Application No: Y/127/21/RES

Site Address: Land at Bilsham Road Yapton

Description of works: Approval of reserved matters (appearance, landscaping, layout and scale) following the grant of Y/91/17/OUT for 250 No dwellings with associated parking, road/footway/cycleway provision, open space, landscaping, surface water attenuation & ancillary works (resubmission following Y/152/20/RES). this site is not CIL Liable as in Yapton Strategic Site.

Thank you for your internet representation made on 4th January 2022 which has been recorded as an objection with the comments as follows:

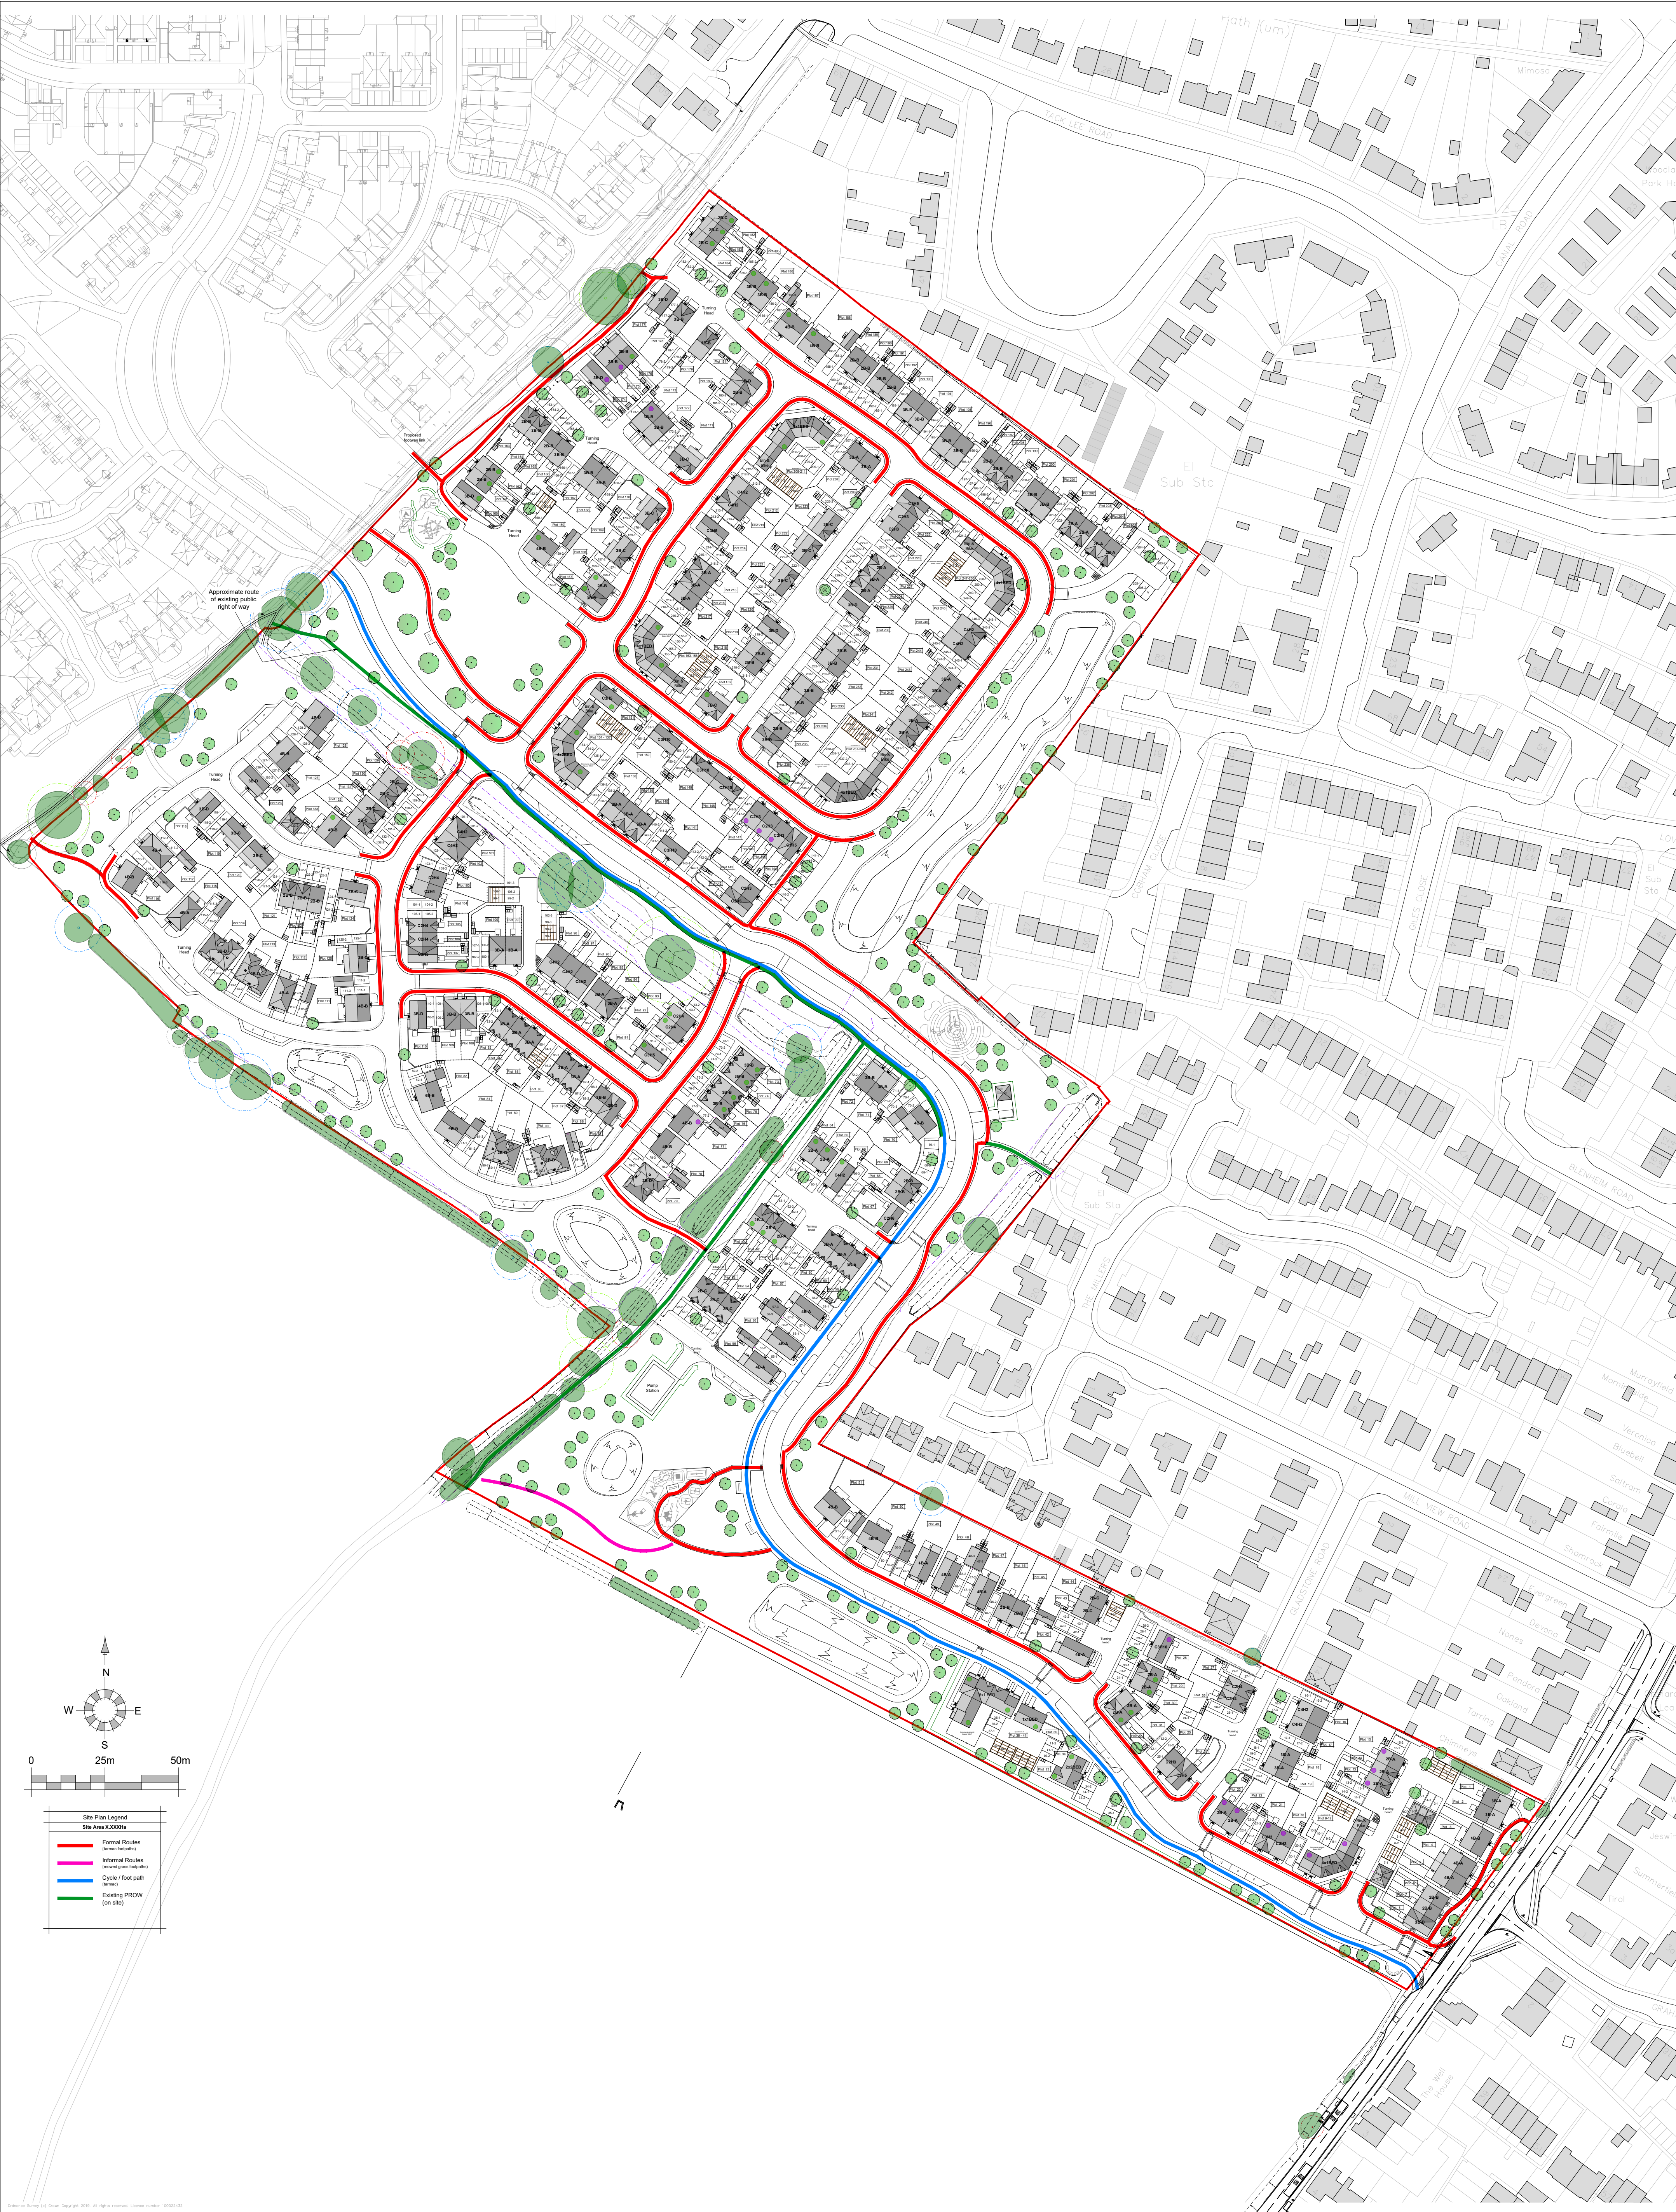
On first glance it looks that the layby won't be impacted by the development however on closer inspection and some discovery it has been confirmed that this layby will no longer exist due to a footpath that will be put in place to link the bus stop to the new estate and the visibility splay required to access the new estate entrance.

It has been said that WSCC has not requested for a layby to be incorporated into the layout and plan. This may be an oversight on the councils part, or it may not have been brought to their attention. I am requesting that there be a layby incorporated as a safe place to deliver or for residents & visitors to park to the properties at this end of the village. Once lost this can never be recovered, I feel its important to secure this before it is too late. The road is becoming increasingly busier and with this development and the one that is potentially going to follow alongside in the next field along Bilsham Road for 200 more houses (Y/116/21/ESO) the road will need more than ever to have a safe space to pull in or park. You will see from all older roadside properties in the village they have some form of layby parking throughout the village, this can be seen by the properties either side close to Drove Lane, by the cottages close to Bilsham stores, North End Road. Formal or informal they are a necessity.

My second concern is the number of houses which are proposed to be facing Bilsham Road, this should be in keeping with the street and be spaced in accordance with the other houses on the street and also as green as possible with maintained trees and grass to compensate for the loss of the outlook over fields.

lastly the plans show a bench on the entrance to the estate, could this encourage people to hang out in this area? Is the bench there for a particular reason. I feel the benches should be where there is a nice outlook and nature area rather than on the corner of the road.
